A585 Windy Harbour to Skippool Improvement Scheme

TR010035

7.11 Environmental Statement Changes and Corrections Document

May 2019

Rev	Status	Rev. Date	Purpose of revision	Drawn	Check'd	Appr'd
1	SS	MAY19	S8 - DEADLINE 2 SUBMISSION	JN	KB	NH
0	SS	OCT18	S8 - DCO SUBMISSION	JN	KB	NH

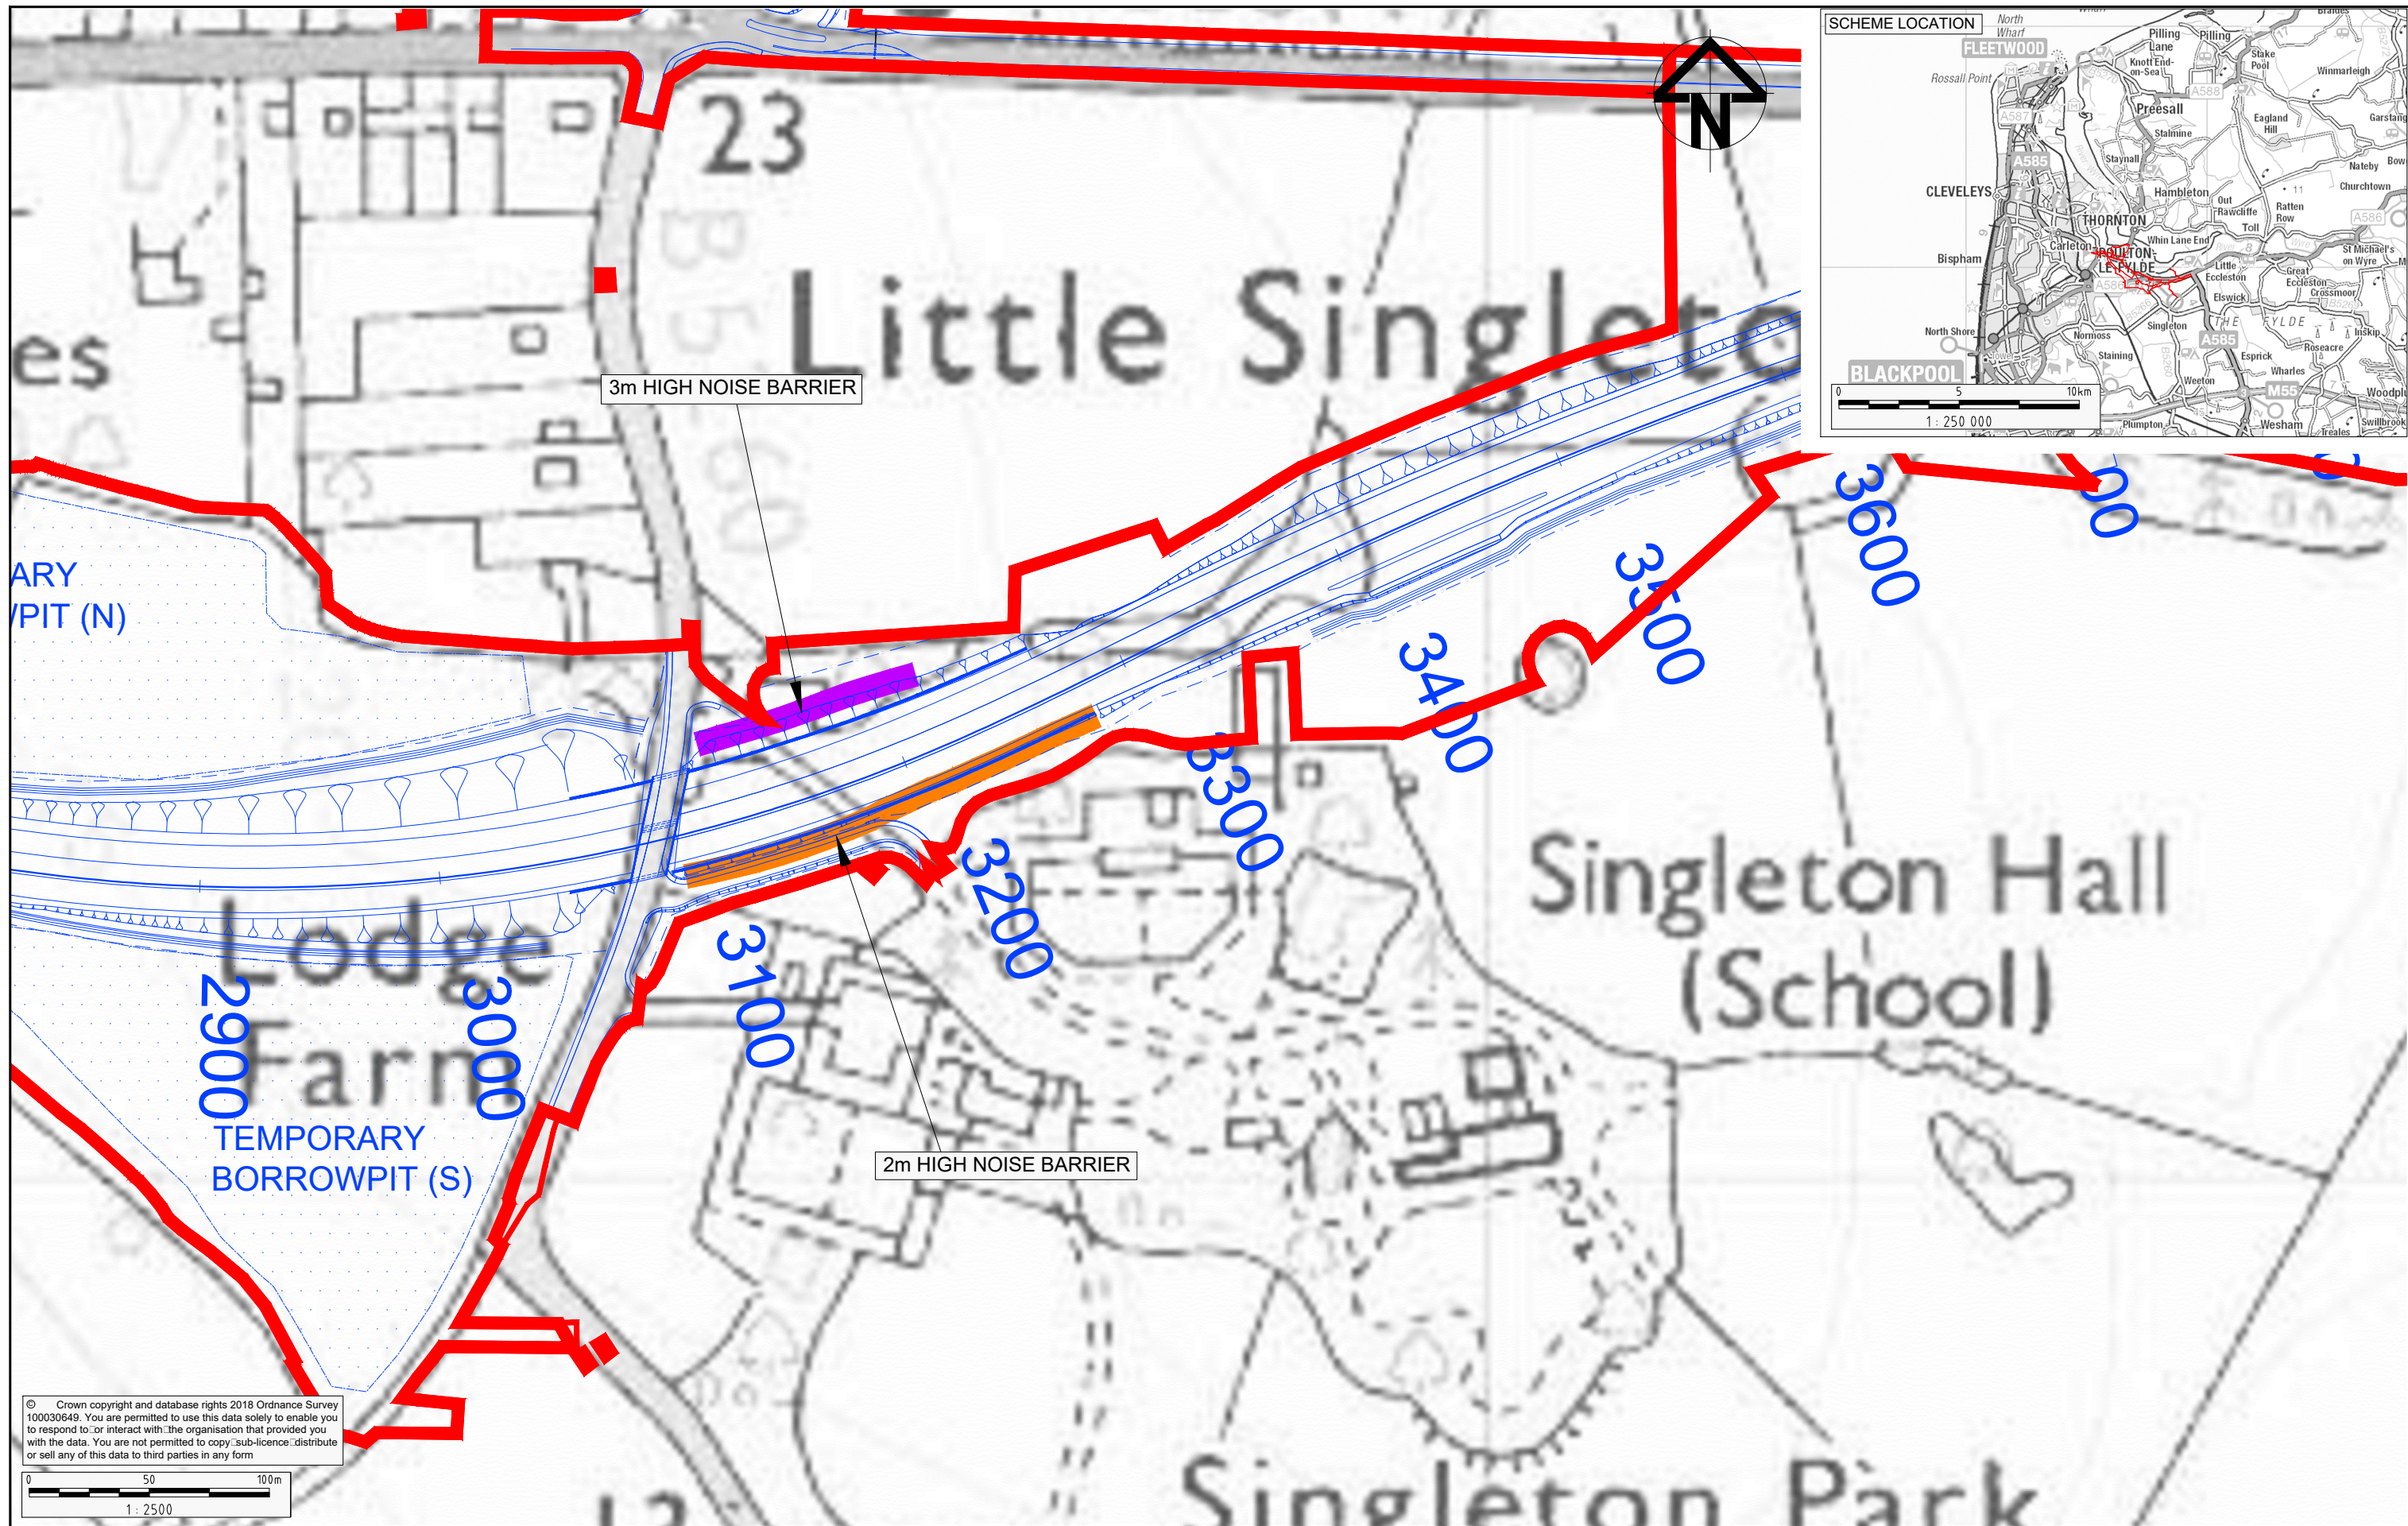
6.11	ES Chapter 11: Noise and Vibration	Update to Figure 11.4: Noise and Vibration – Noise Mitigation within the Study Area presented at Appendix D to show heights and locations of earth mounds and acoustic fencing at a larger scale.	Requested by the Inspector within the first round of written questions (document reference TR010035/APP/7.10).

APPENDIX F – Updated Figure 12.2: Road Drainage and The Water Environment - Aquifers

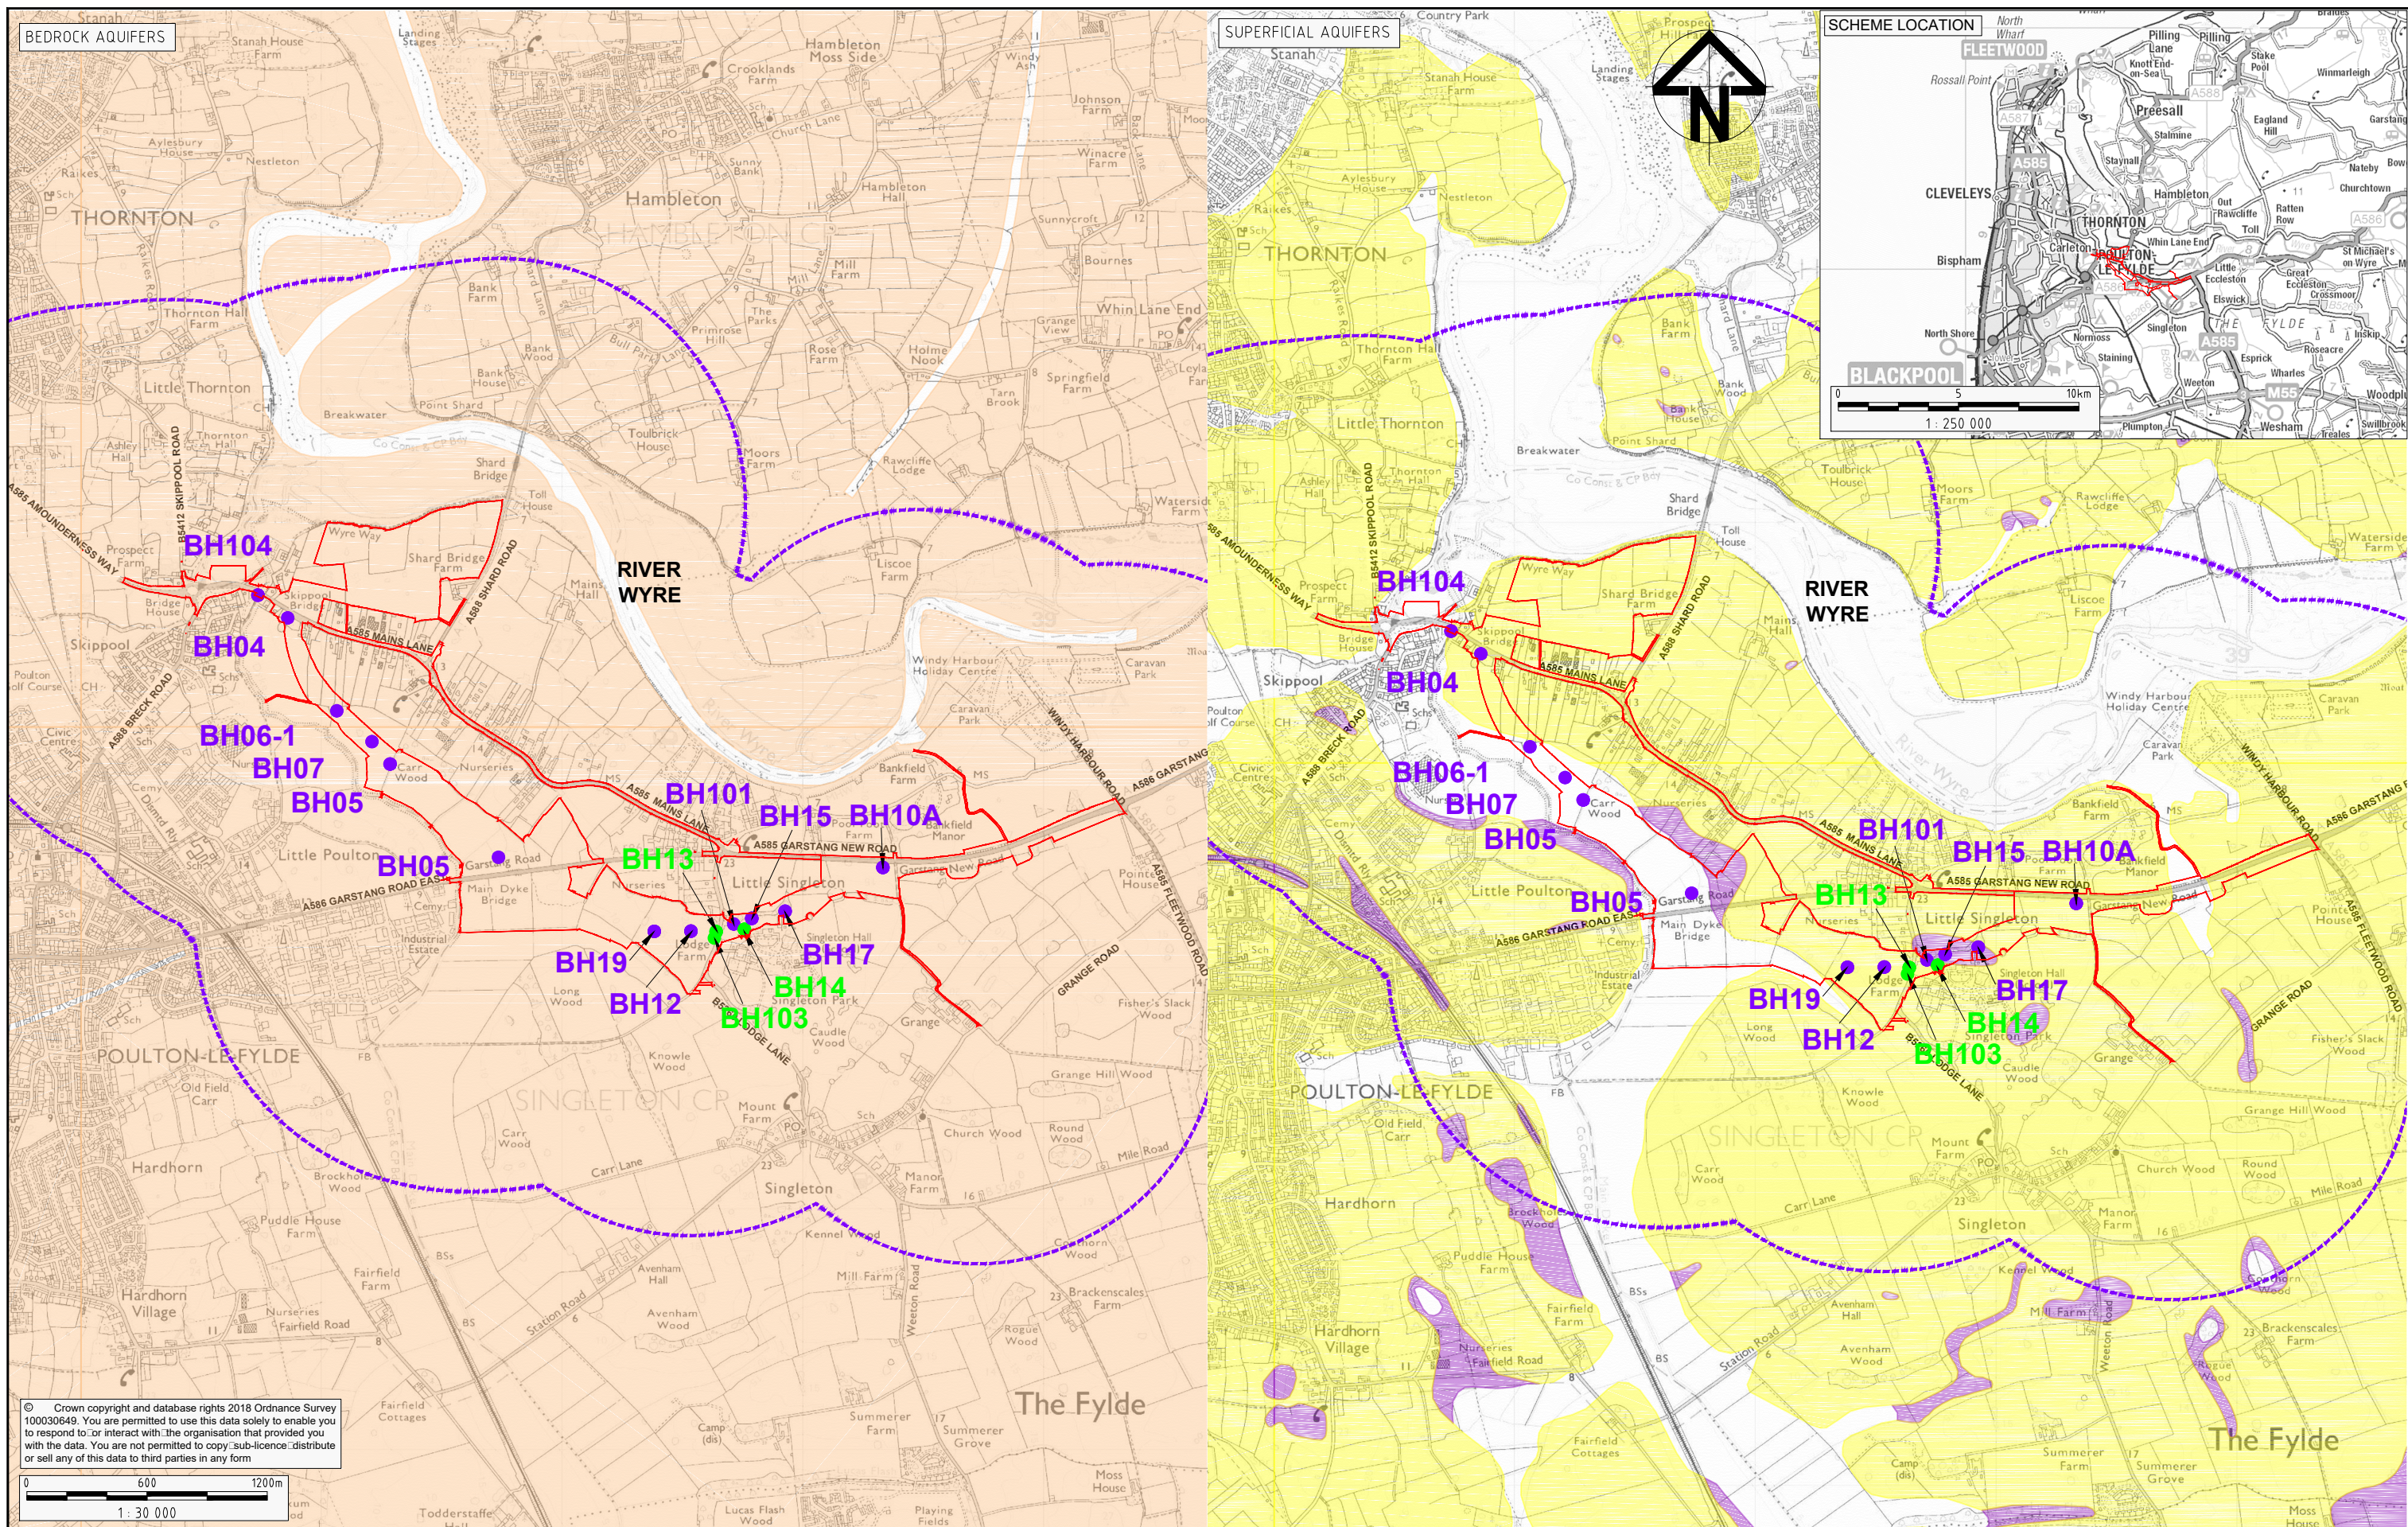
Appendix E	– Updated Table 4-1 within Appendix 11.3 (document reference TR010035/APP/6.11.3).....	34
Appendix F	– Updated Figure 12.2: Road Drainage and The Water Environment - Aquifers	36
